DECISION DELEGATED TO DEVELOPMENT MANAGER

Application No: H16-0078-21 **Applicant:** McAfee Design Ltd.

Proposal: Details of foul water disposal, surface water drainage, external materials, boundary treatment and landscaping (Conditions 3, 4, 5, 6 & 7 of H16-0022-19)

Location: Land North Of 13 Palin Drive Spalding

PROJECT
Palin Drive, Spalding
DRAWING TITLE
Planning Conditions

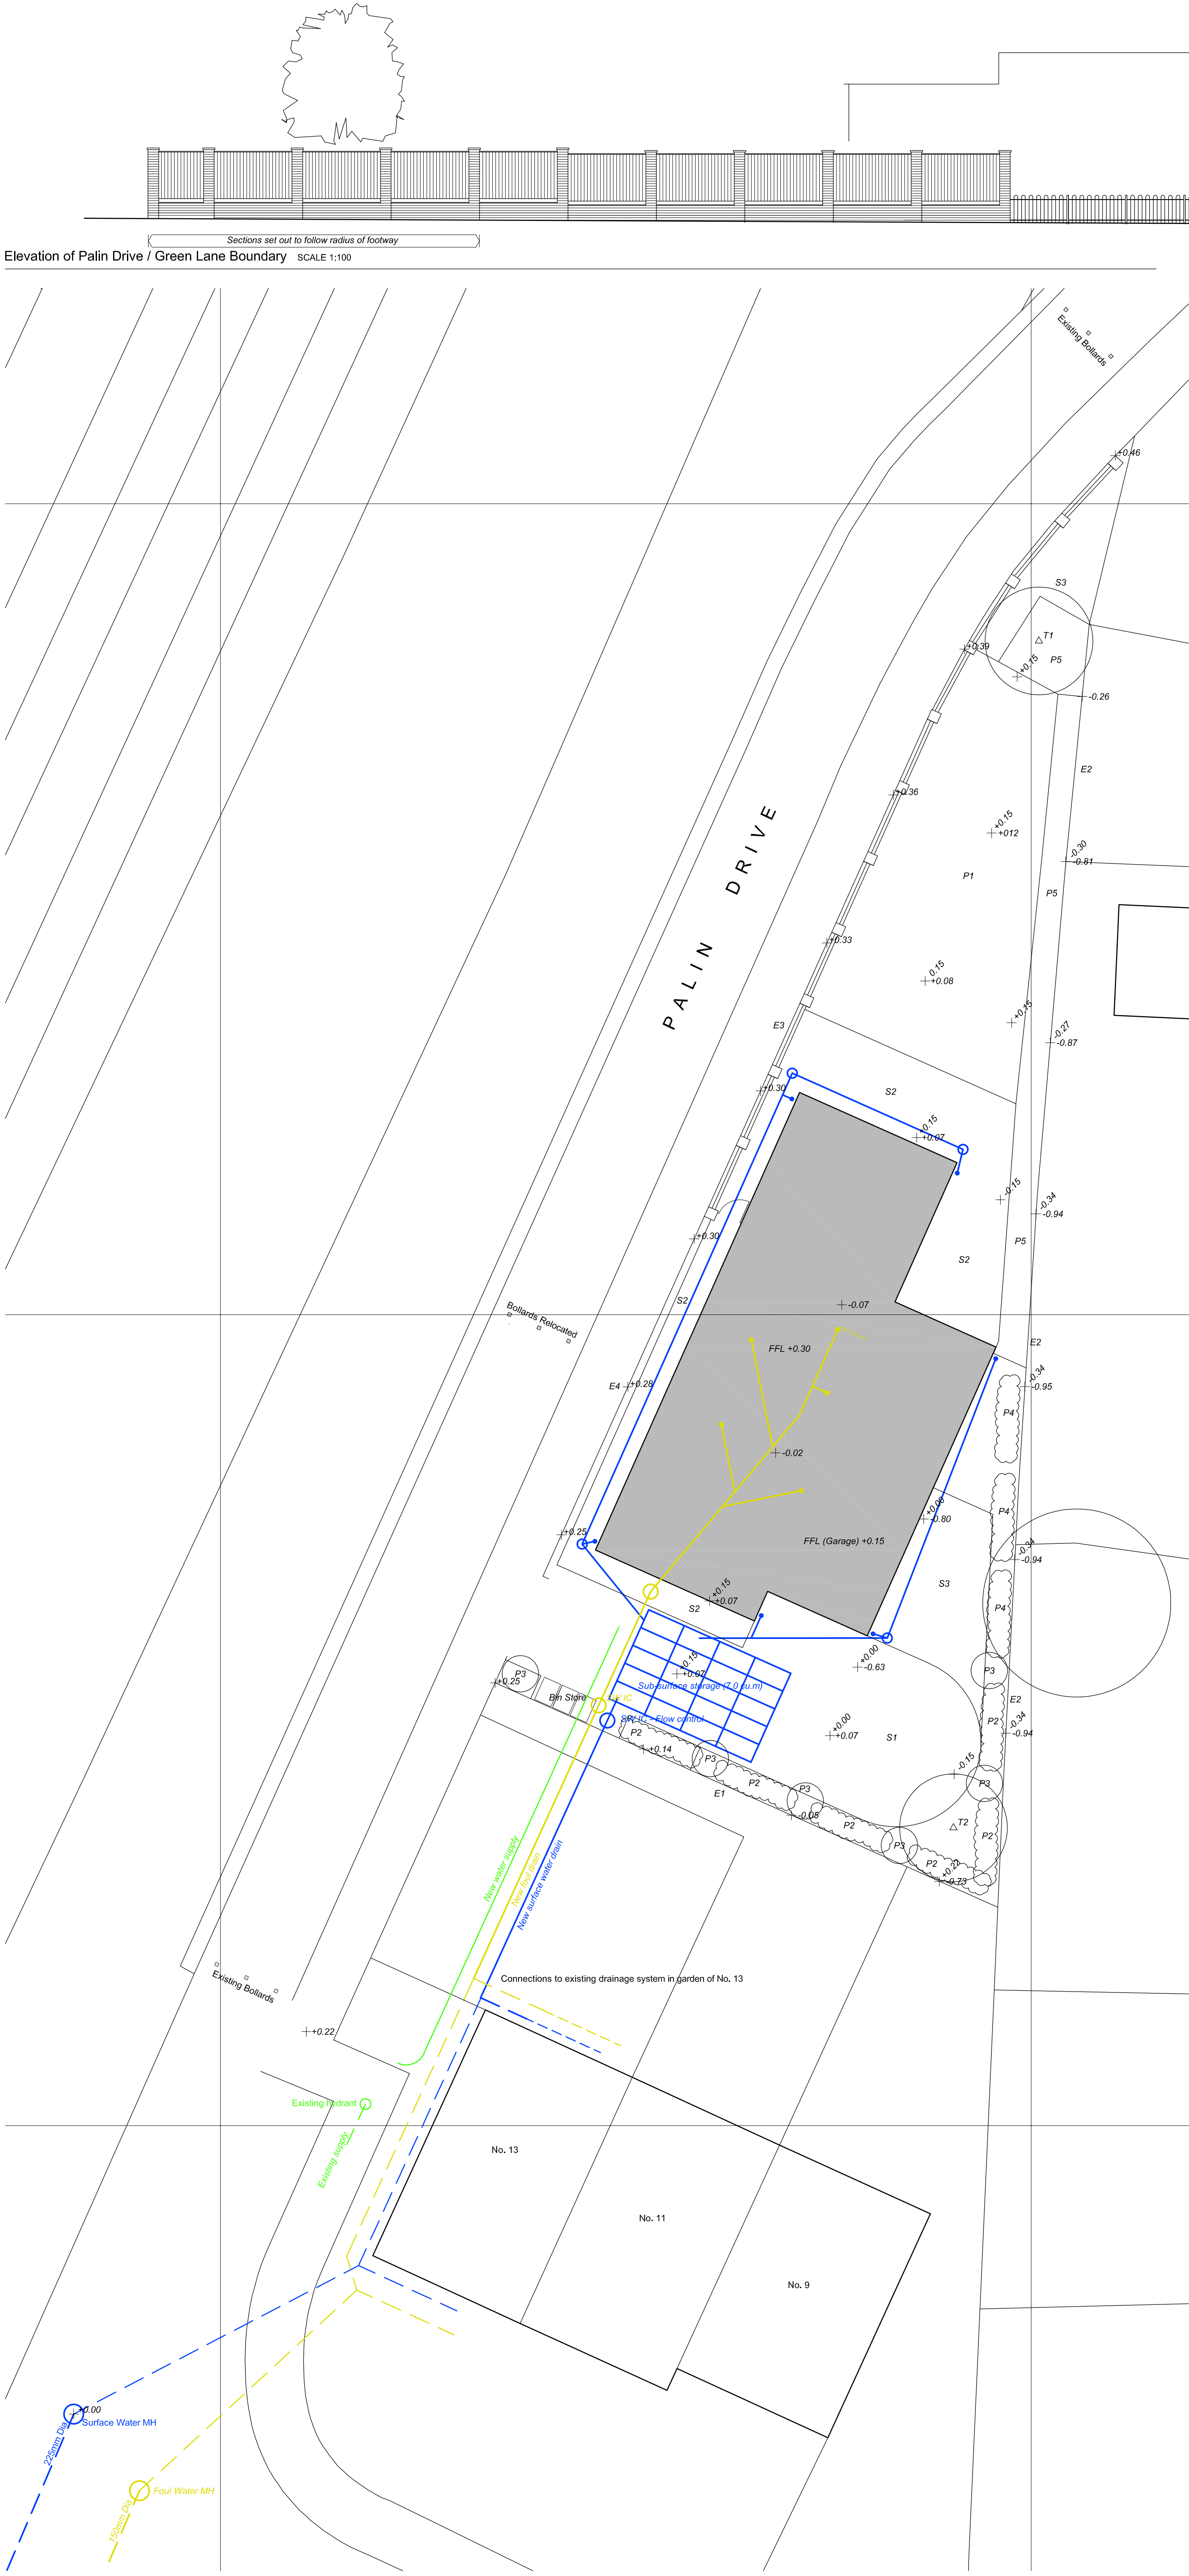
Condition 3 (foul water drainage) - Proposal is to make connection to the existing Anglian Water network. This is an acceptable arrangement.

Condition 4 (surface water drainage) - The proposal is for sub-surface geocellular storage beneath the driveway which will be connected to the wider drainage system in the rear garden of no. 13. Ordinarily, soakaways would be the preferable surface water drainage solution for a scheme of this nature and size, however the size of the plot makes the use of soakaways problematic (given they have to be 5 metres away from structures and the highway). In light of this, the proposed drainage scheme is acceptable.

Condition 5 (materials schedule) - Proposed materials of construction are Ibstock Grosvenor County Mixture bricks above DPC, Marley Anglia Antique Brown roof tiles and white UPVC fenestration. This would be in keeping with existing development in the vicinity. The driveway would be permeable block paved which is acceptable in visual terms and for drainage reasons.

Condition 6 (boundary treatment) - The proposal is to rely upon the existing close board fence along the southern boundary and repair where necessary. Along the eastern boundary, a 1.8m timber close board fence is to be erected above concrete retaining boards. The level at the boundary is to be raised by approximately 600mm with the base of the retaining board being at this level. The finished floor level of the property would be at a similar level with the remainder of the garden being at a slightly lower level. Given this, it is not considered that there would be a material overlooking impact on neighbouring properties and the fencing should be at a height which would not be perceived as overbearing. To the western boundary, extending alongside the garden will be a brick dwarf wall and pier infilled with timber close board fence, totalling 2.1m in height. The remainder of that boundary as far as the driveway would be painted steel hoop top railings.

Condition 7 (landscaping) - The garden area would be a combination of turf and buff paving with planting beds, shrubs and trees along the eastern and southern boundaries. This is an acceptable scheme given the size of the site.
